Rezoning Transportation Analysis

Petition Number: 2022-200

Revision Log:

Date	Description
4-27-23	First Review (TM)
05-24-23	Second Review (TM)

SCHEMATIC SITE PLAN

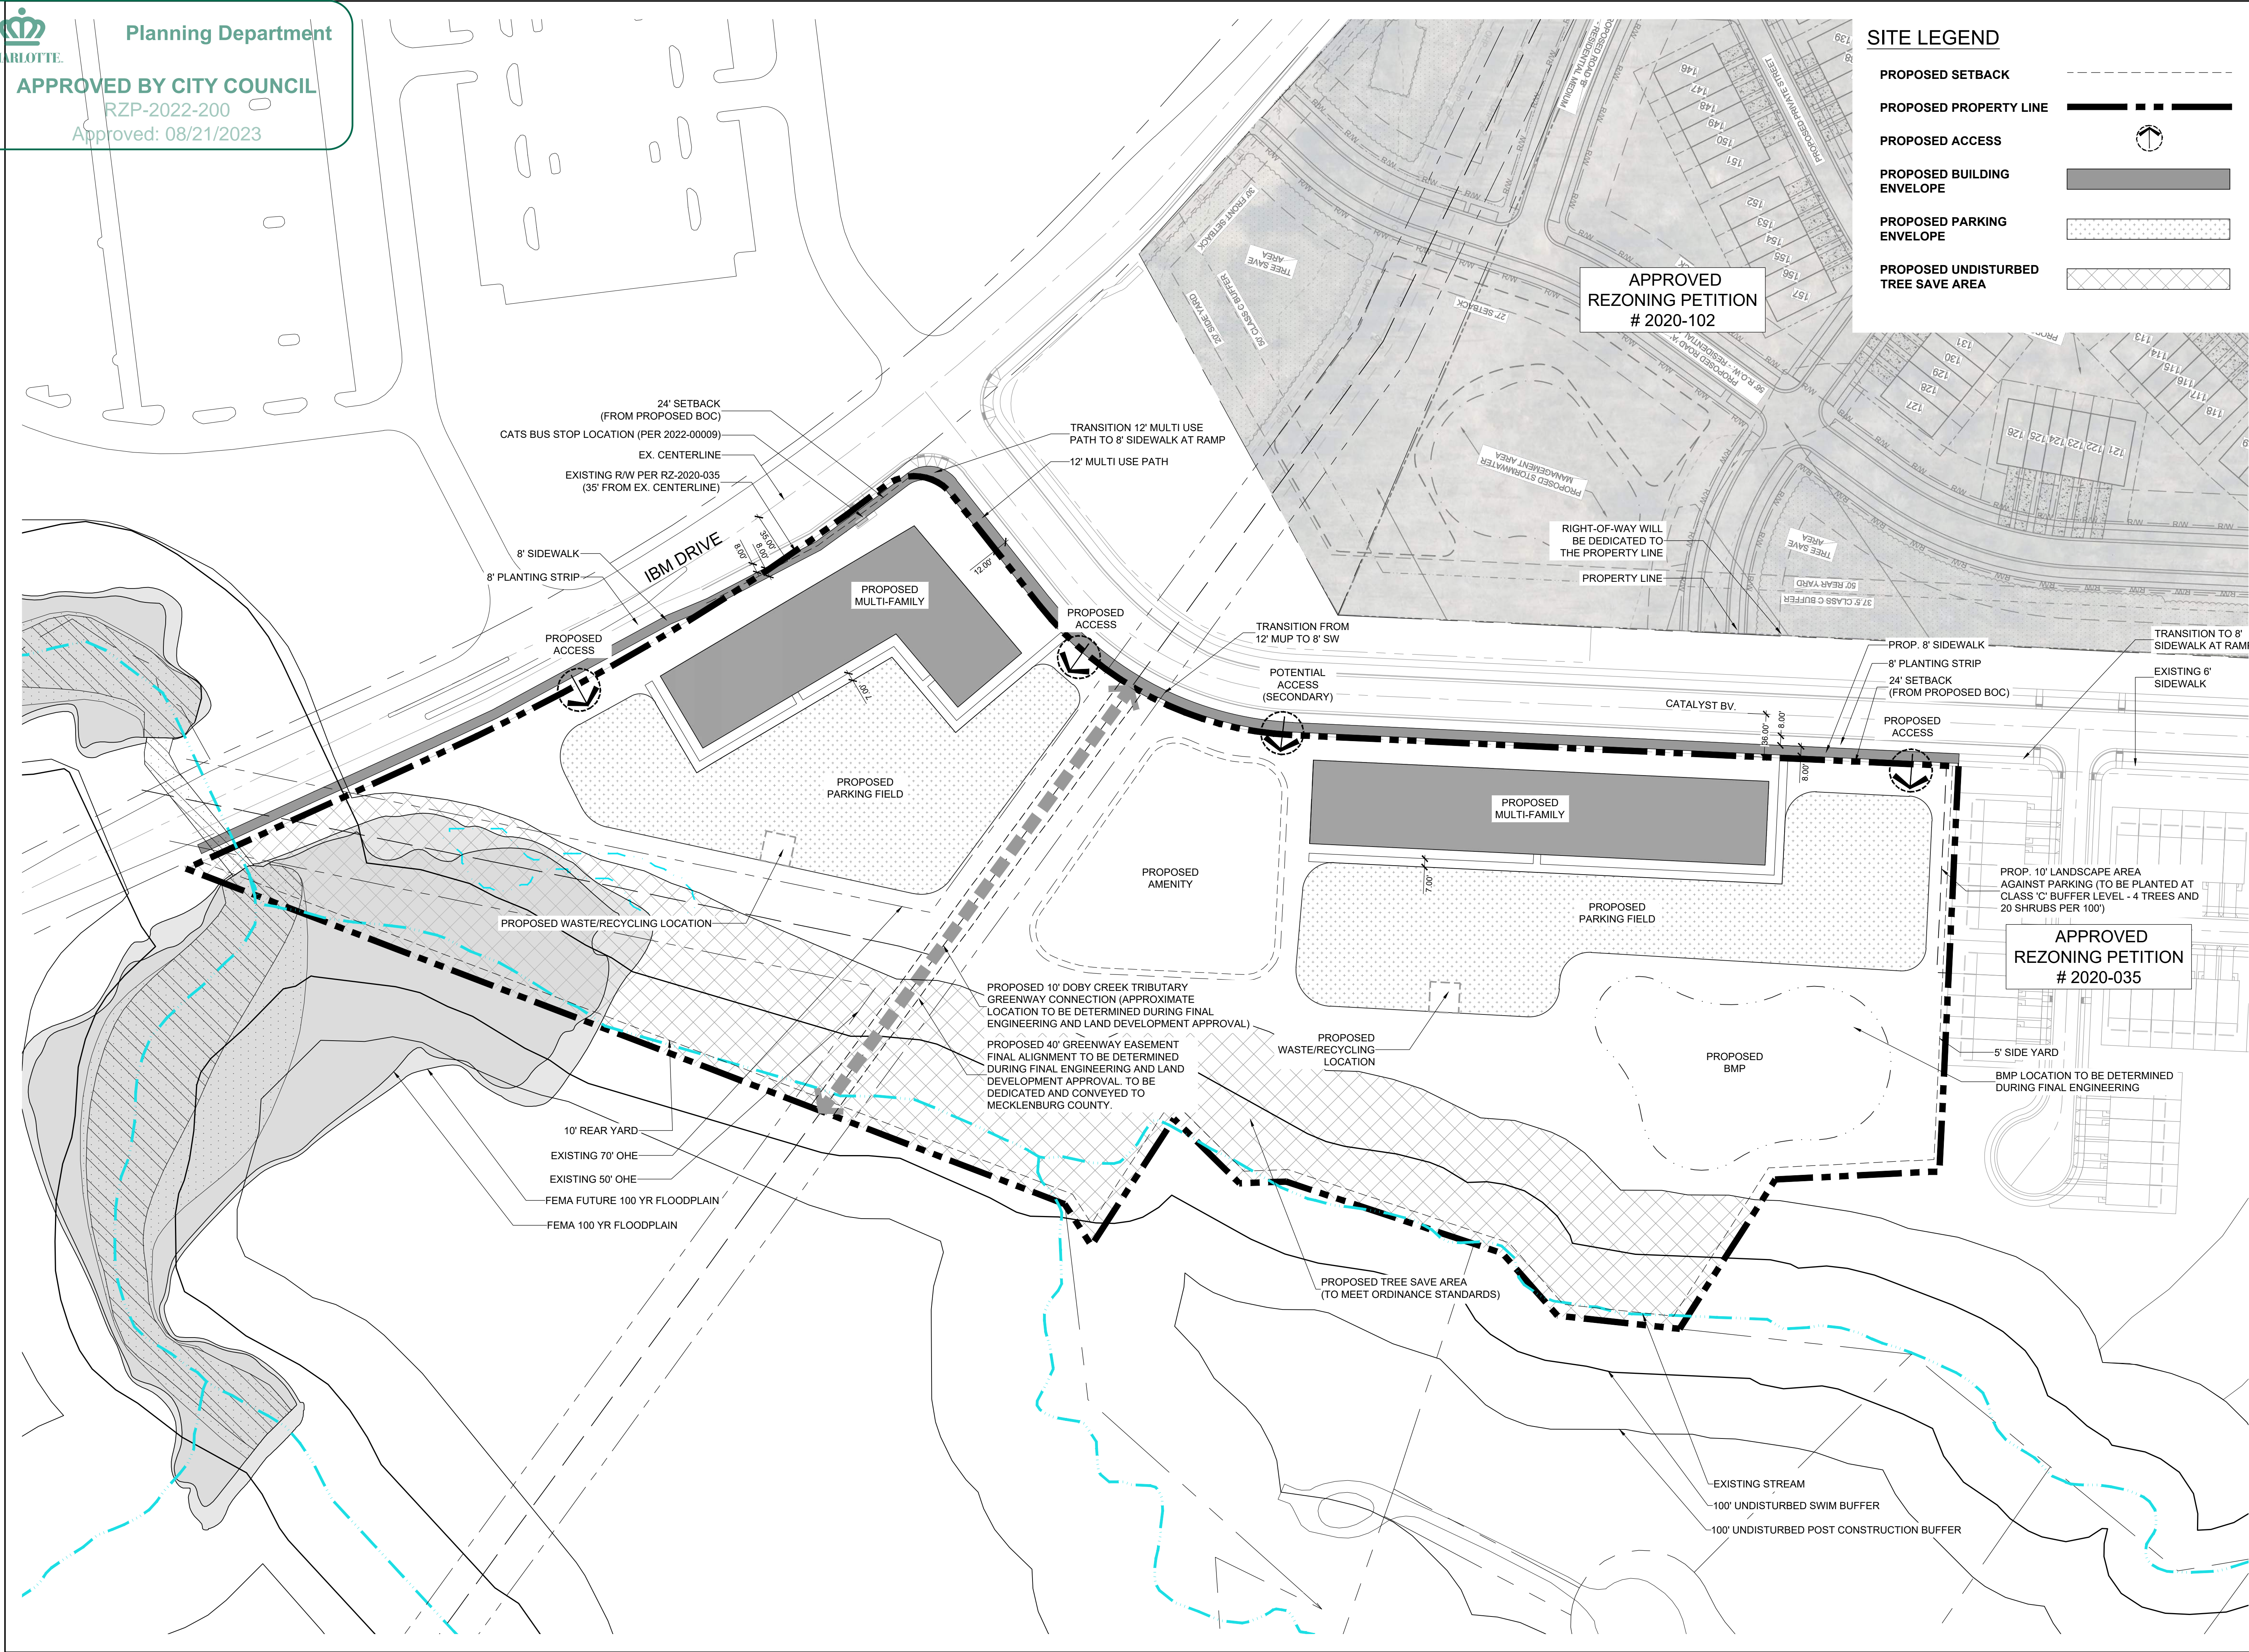
Label and dimension the curb and gutter from the centerline for each road on the site plan.

7. ~~Revise site plan and conditional note(s) to commit to installing a 2 (inbound and outbound) CATS bus stops on IBM drive.~~
8. **Outstanding Comment from 04-27-23:** Revise site plan and conditional note(s) to commit to revising southern access location to align with the adjacent development access shown from rezoning 2020-102. **Clarifying Comment 05-24-23** Show access as relocated to align or remove from plan.
